Application No: FP/262/21/PL
Site Address: Mast at Felpham Way Bognor Regis PO22 8PS
Description of works: Erection of EE/H3G 15m High Phase 8 Monopole to replace existing EE/H3G 12.5m Phase 5 Monopole and associated ancillary works. This site is in CIL Zone 4 (Zero Rated) as other development.

Thank you for your internet representation made on 7th January 2022 which has been recorded as an objection with the comments as follows:

002 SITE LOCATION PLAN

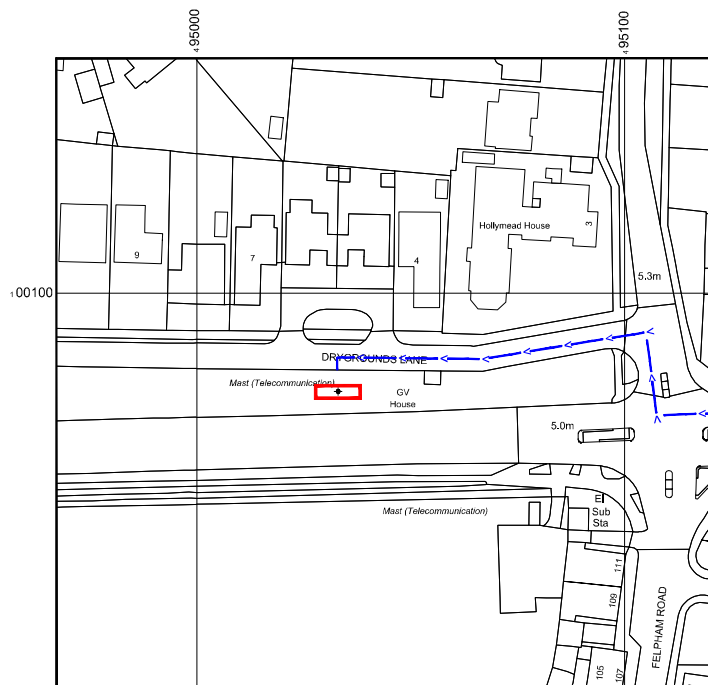
The Site Location Plan shows the extent of the 'Site Provider's Property Boundary'. However none of the proposed works appear to be contained within the confines of the area so indicated, why is this?

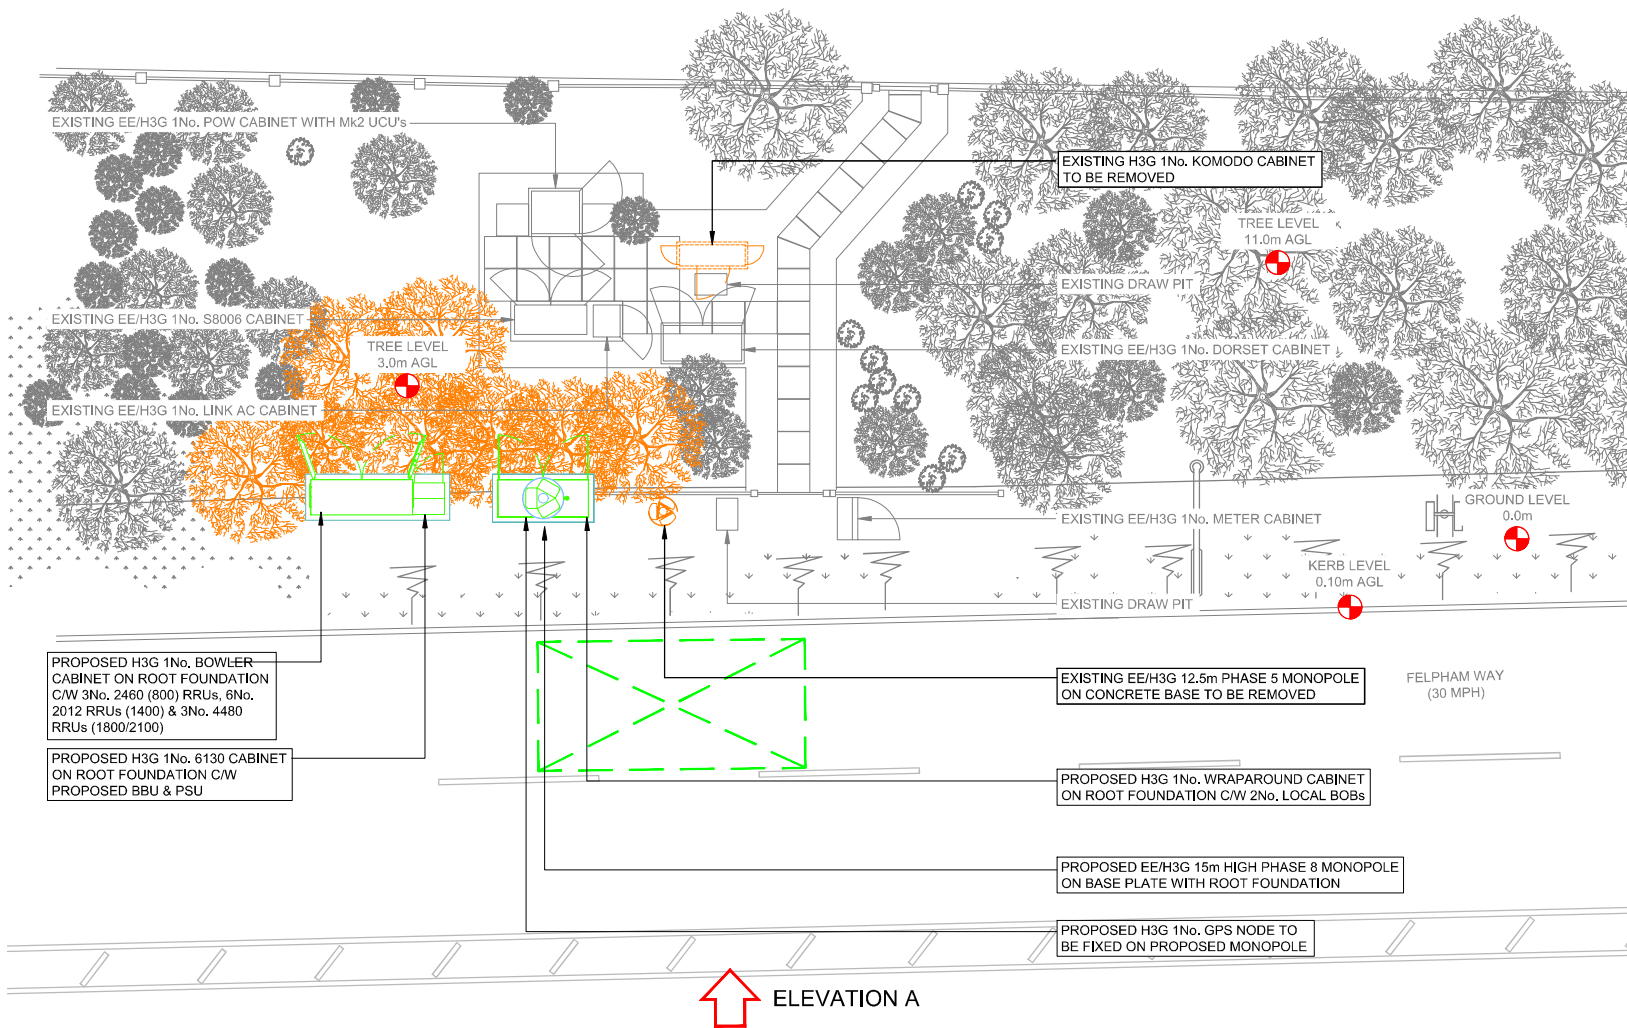
The application states that 'Existing trees and shrubs are to be cut back to allow for new pole installation, exact details tbc on site'. I do not think this is adequate detail on what the proposals are and the effect they will have.

All drawings appear to have the same number so I will refer to them by their title. On both the 260 Proposed H3G Site Elevation and Site Plan the existing pole and one existing cabinet are identified to be removed and these items are coloured orange; however a number of trees and shrubs on these plans are also coloured orange, does this infer that these items are also to be removed? If not, why are they coloured in this way?

I also would like to know why the 2 new cabinets (not the pole itself) are not being placed within the tree screened area, perhaps in a similar location to the cabinet that is being removed. This would surely ensure less adverse effect on the existing trees/shrubs as it appears a lot of the proposed removal and cutting back are to accommodate access to these new units. There appears to be a draw pit access to this existing site which would also minimise the disturbance of trees/shrubs.
